**Concept Plan (Stage 1) Development Application for 301-305 Kent Street, Sydney  
(SSD 9694)**

Thank you for your letter, requesting Transport for NSW (TfNSW) review and comment on the above.

Lower Ground Level

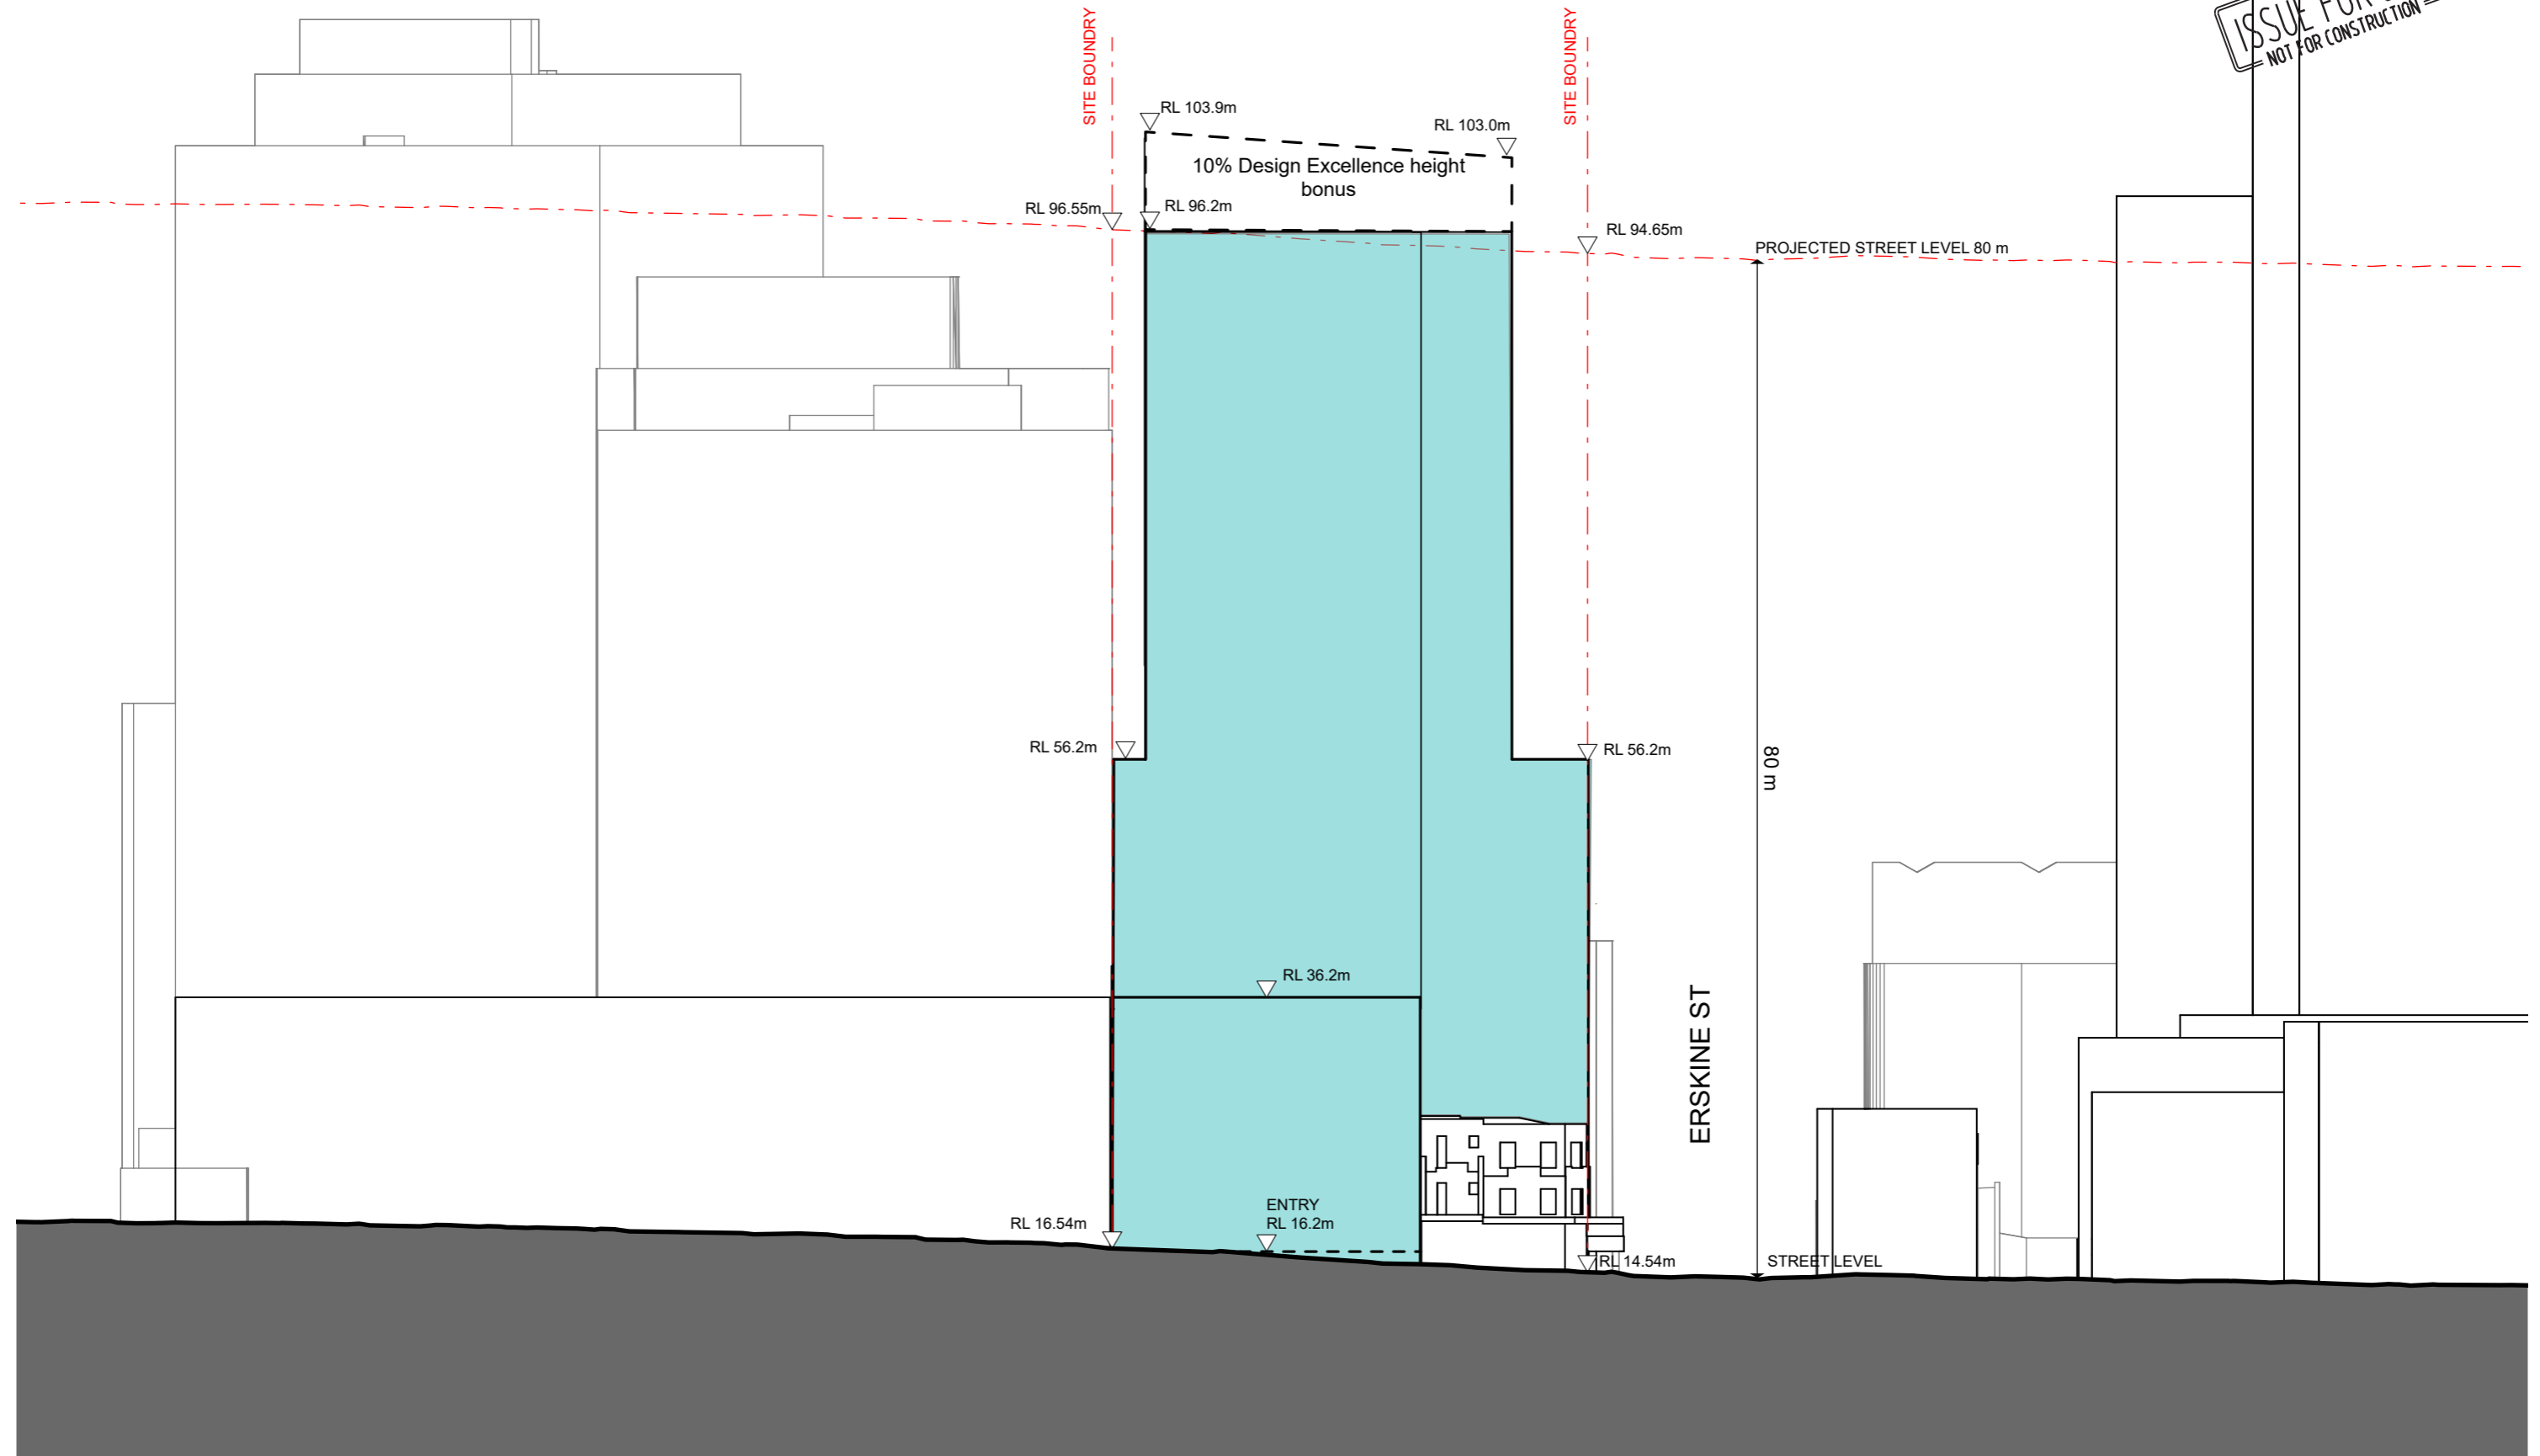
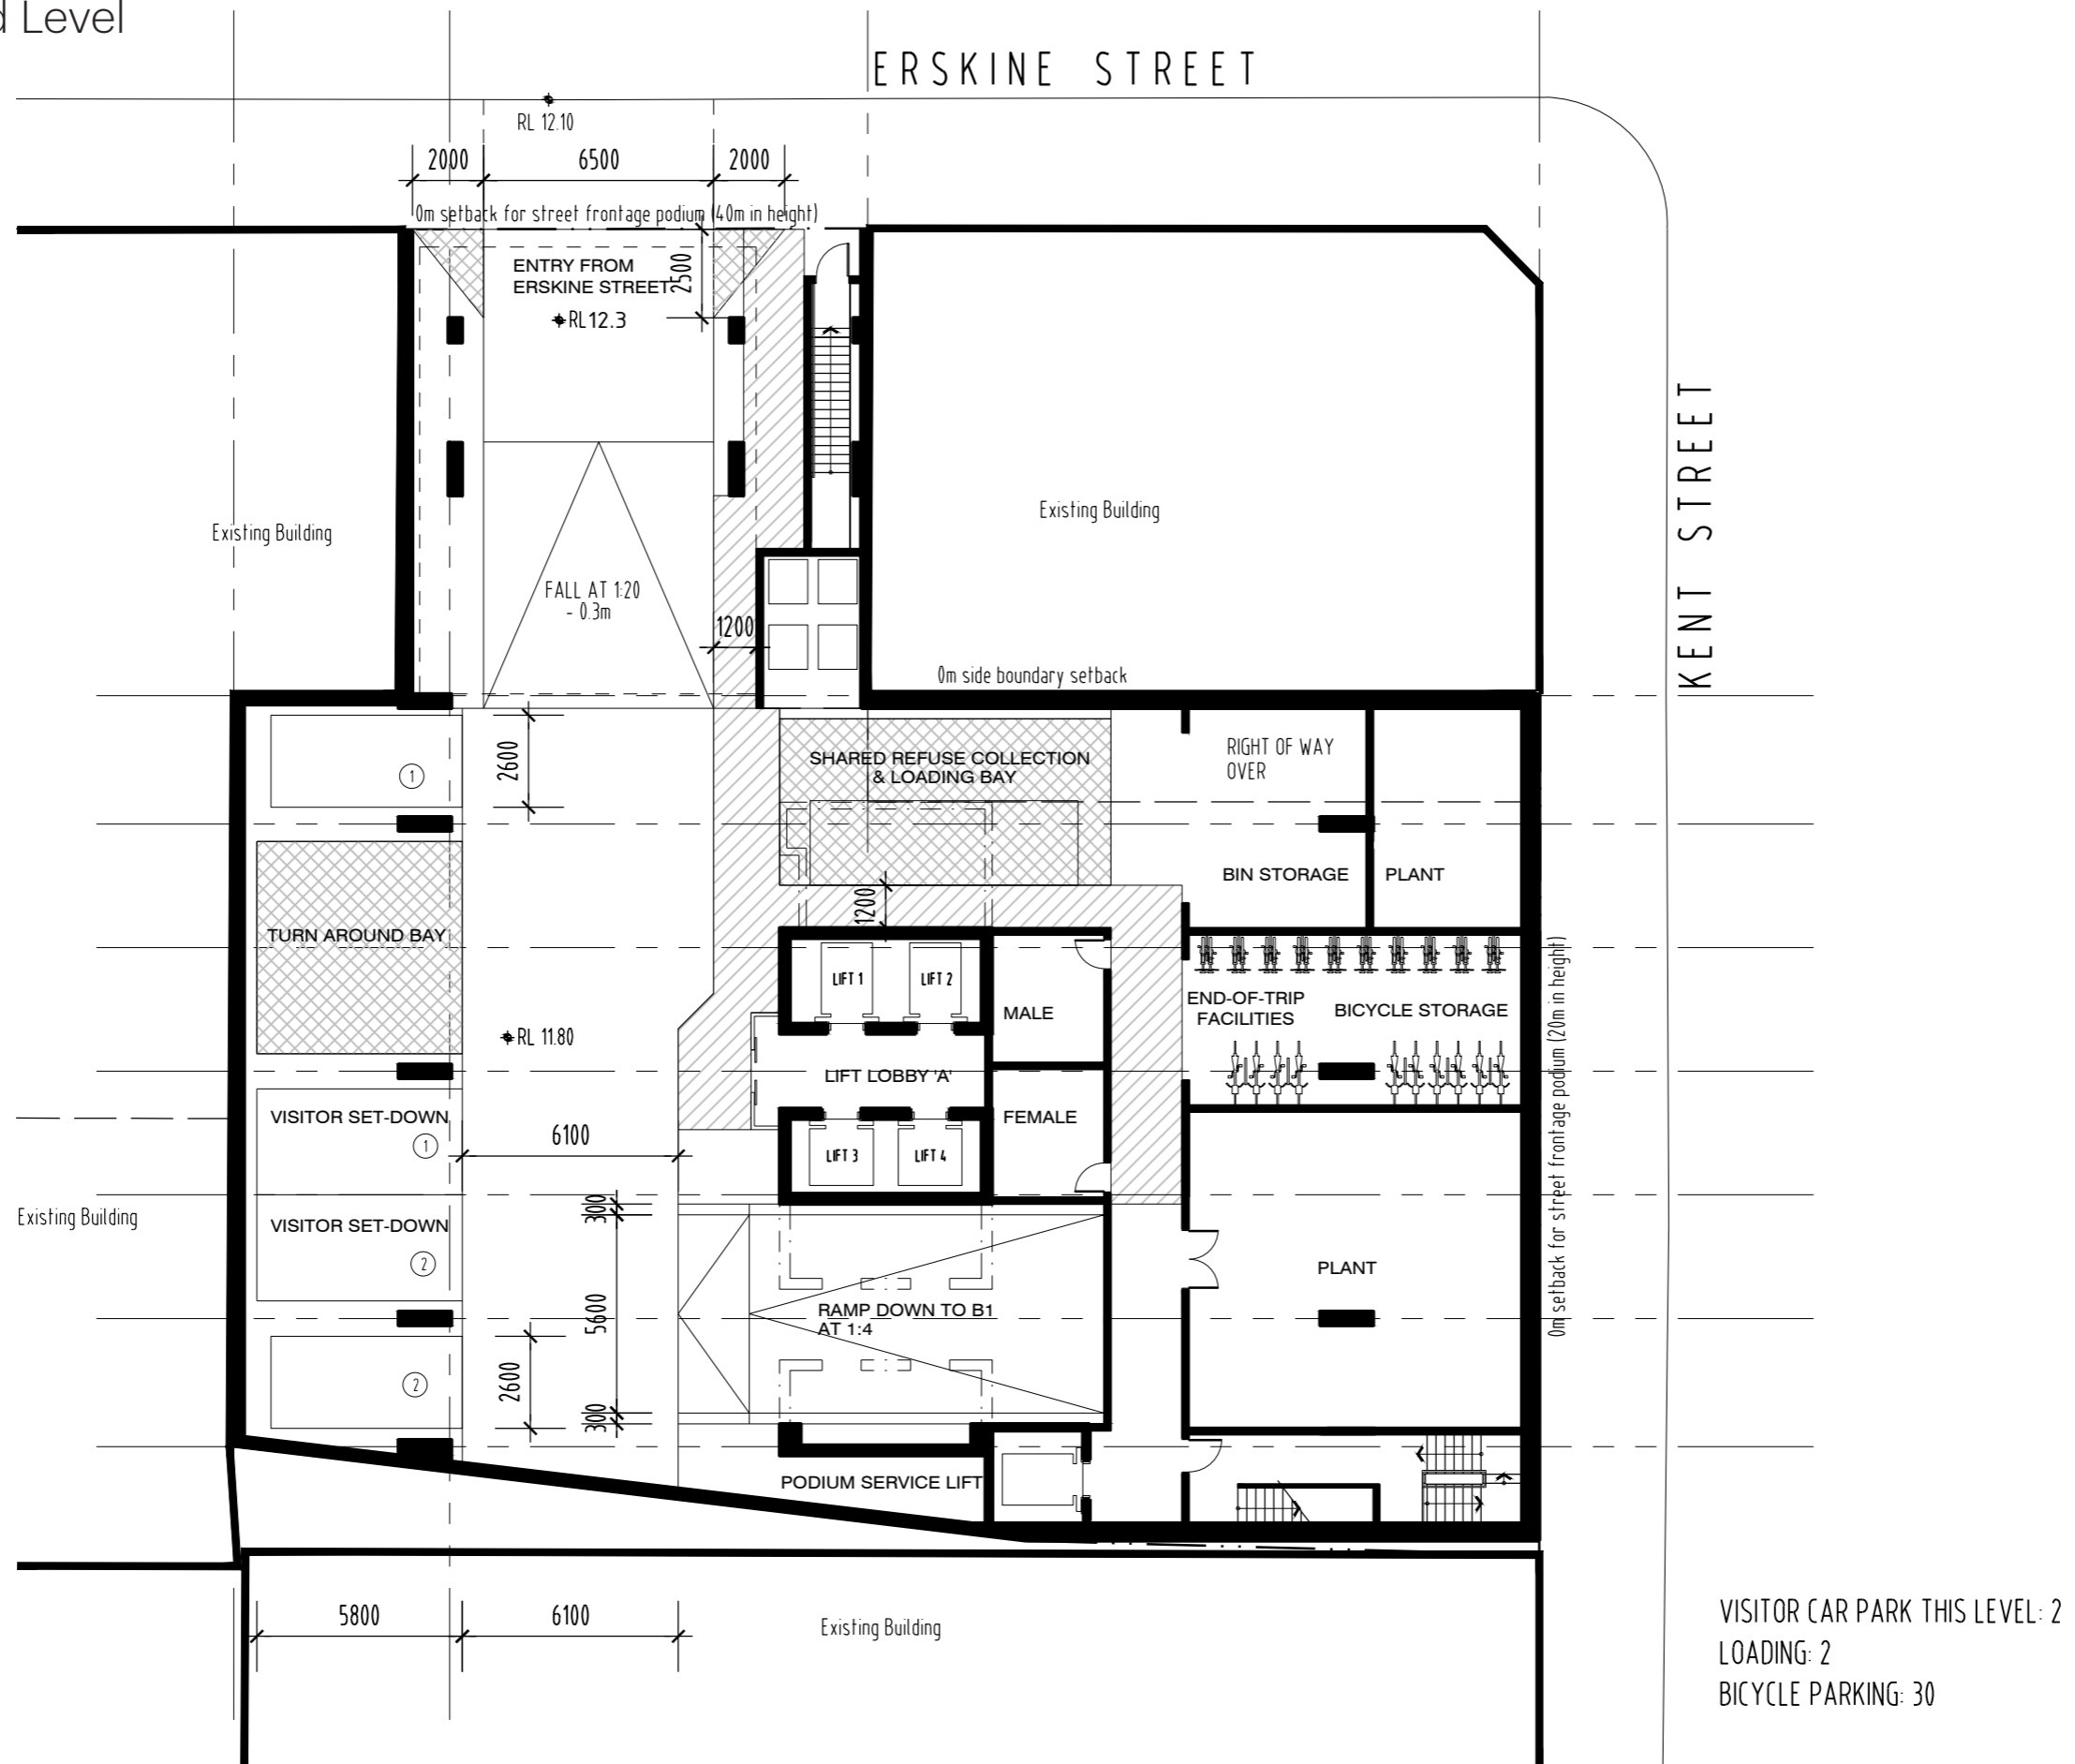
The Vehicle Access and Pedestrian Impact Assessment Report prepared to support the development application states that the proposed development includes a new basement driveway access on the Erskine Street frontage of the site instead of the Kent Street frontage because of a lesser impact to pedestrians as fewer pedestrians were surveyed using the adjacent footpath on Erskine Street than Kent Street.

It is noted that the proposed access arrangement has the potential to cause vehicles to queue through the Erskine Street/Kent Street intersection, impacting the operation of the intersection and in service and out of service buses along Erskine Street frontage due to the conflicts between vehicles entering and exiting the basement and pedestrians at the proposed basement driveway.

It is requested that as part of the Response to Submissions report, the applicant undertakes a detailed assessment that shows the proposed access on Erskine Street frontage would be the preferred arrangement compared to an access on Kent Street frontage in terms of general traffic and bus operation in the vicinity of the subject site.

The Traffic and Parking Assessment Report (Traffic Report) prepared to support the development states that service vehicle requirements to the various components of the 360 hotel accommodation rooms is five (5) spaces and the proposed development provides (3) service vehicle spaces comprising 1 space for SRV trucks and 2 spaces for light commercial vehicles.

- As noted by the proponent, the proposed development does not provide adequate freight and service parking on-site to support its operation. Unmanaged, the proposed development activities would have the potential to contribute to congestion within the CBD by freight and service vehicles circulating through the CBD to find a loading zone as limited on-street loading zones are available surrounding the site to accommodate the demand from the proposed development; and
- The applicant should not rely on the kerbside restrictions to conduct their business activities.

- Justification for the number of loading dock spaces including assessment of the freight and servicing profile, including the forecast freight and servicing traffic volumes by vehicle size, frequency, time of day and duration of stay; and
- If the demand is not met on-site, details on alternative arrangements are to be proposed.

Based on the Waste Management Plan prepared to support the development application, waste collection would be undertaken from the proposed SRV loading bay on the lower ground level, accessed via Erskine Street.

It is requested that as part of the Response to Submissions the applicant confirms that a vehicle larger than an SRV would not be used to collect waste.
